WEST SUSSEX COUNTY COUNCIL CONSULTATION

TO:	Arun District Council FAO: Simon Davis
FROM:	Highways, WSCC
DATE:	23/10/2018
LOCATION:	10, Barrack Lane, Aldwick, Bognor Regis, PO21 4BZ
SUBJECT:	AW/259/18/PL 1 No. dwelling.
DATE OF SITE VISIT:	N/A
RECOMMENDATION:	☒ Advice ☐ Objection ☐ Modification ☐ No Objection ☐ More Information ☐ Refusal
S106 CONTRIBUTION TOTAL:	£N/A

Block Plan 1 : 500

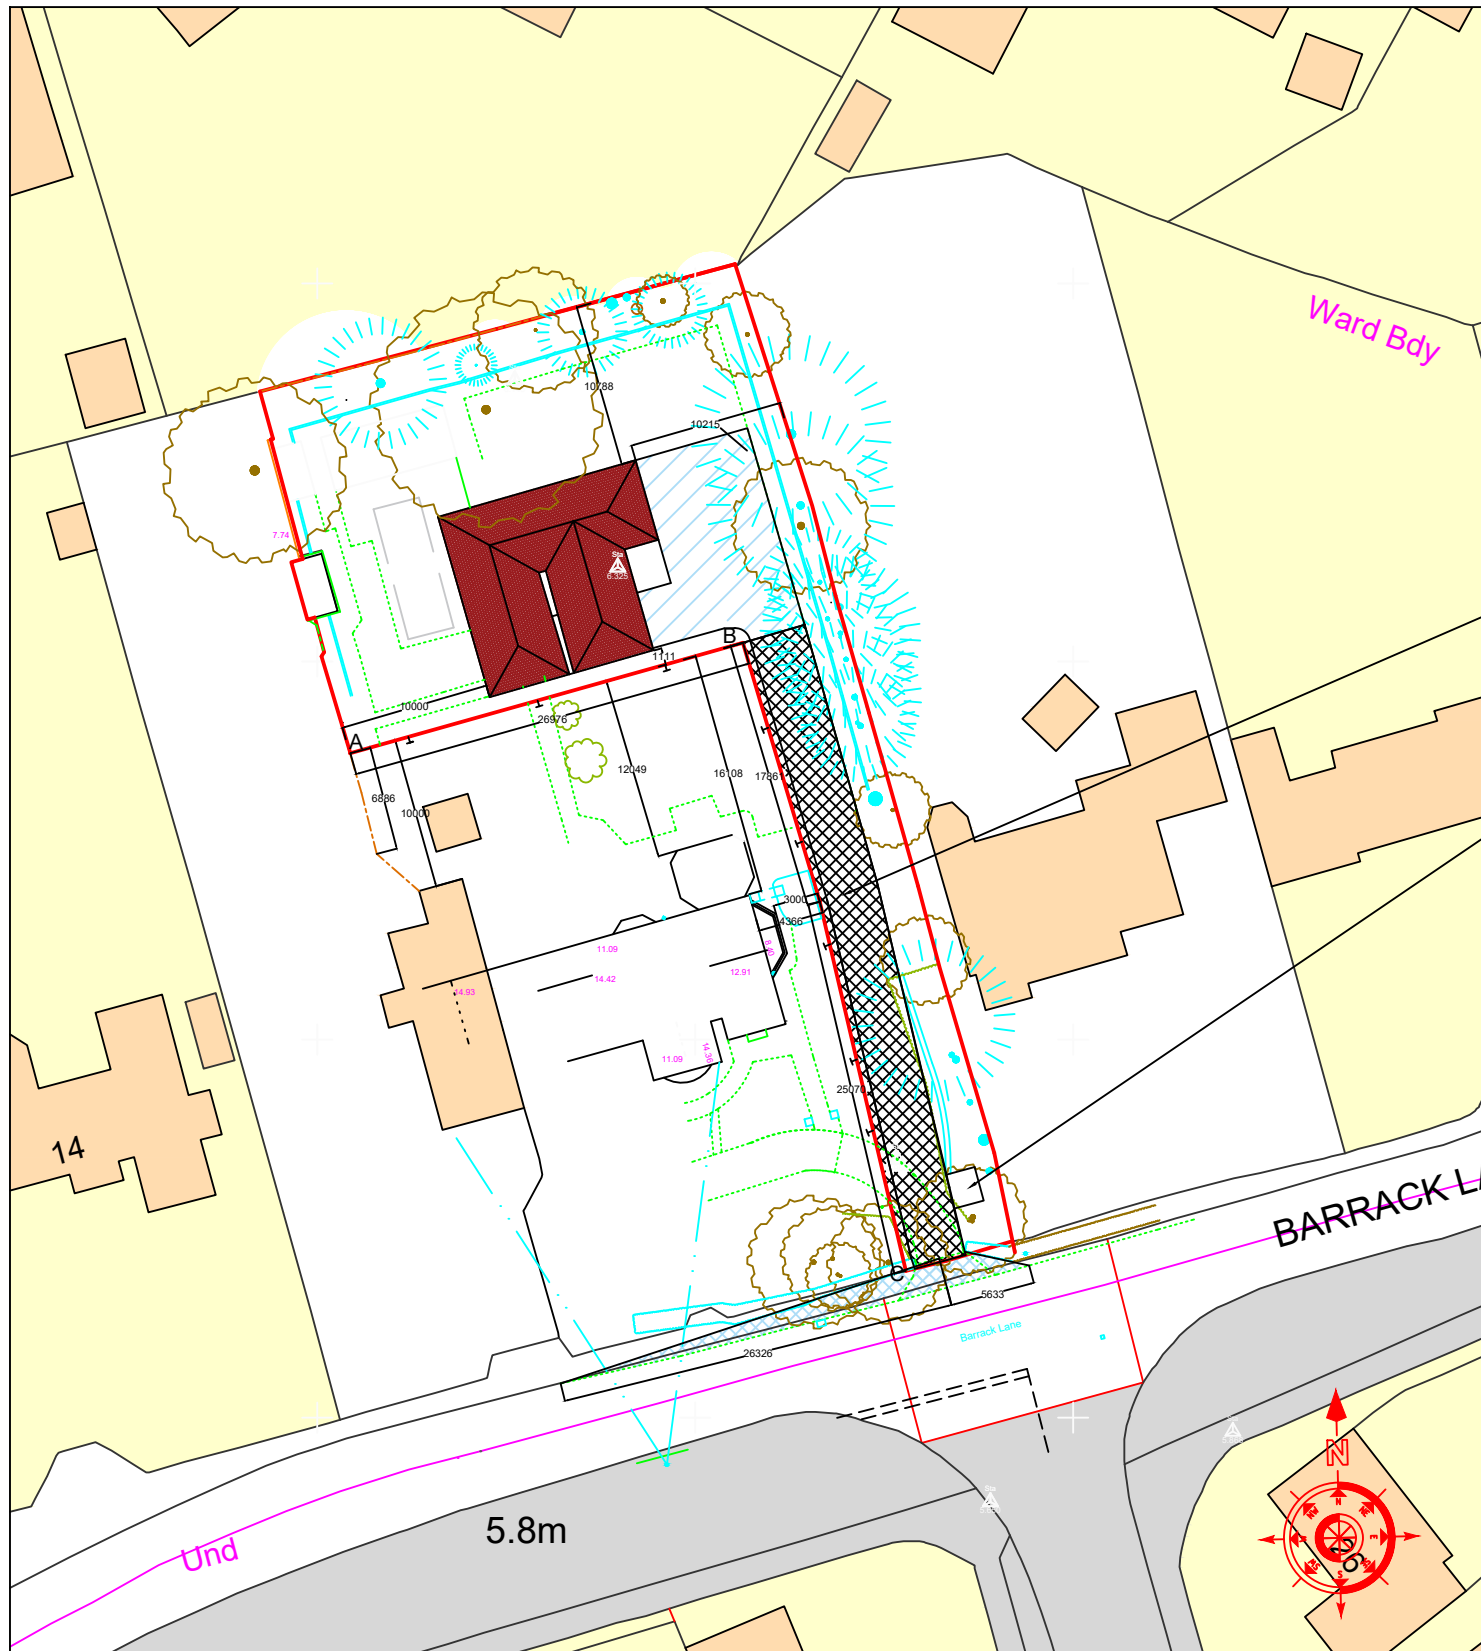
It appears that vehicular visibility splays have been drawn on the proposed plan, although these have not been drawn to WSCC standards. Vehicular visibility at the eastern access appears to be restricted in both directions. As such, maximum achievable visibility splays should be demonstrated at the site access. Splays should be drawn from the middle of the access at a distance of 2.4m from the back edge of the carriageway (X distance). The splays should then be drawn to the *nearside edge* of the carriageway in both directions or at a 1m offset to represent the track of a vehicle as per the image below. Splays may only intersect land within the applicants control or publically maintained highway. Maximum achievable visibility splays can be secured via condition.

The application form indicates that on-site parking will be provided for two vehicles. A parking layout plan has not been provided although there appears to be sufficient space on site to accommodate this parking provision. There also appears to be sufficient space on site for vehicles to turn on site and exit onto the publically maintained highway in a forward gear.

Within six months of the implementation of the development, maximum visibility splays shall be provided at the site access onto Barrack Lane in accordance with a plan to be submitted to and approved by the planning authority. These splays shall thereafter be kept clear of all obstructions to visibility above a height of one metre above the adjoining road level.

No part of the development shall be first occupied until the vehicle parking and turning spaces have been constructed in accordance with the approved plan. These spaces shall thereafter be retained for their designated use.
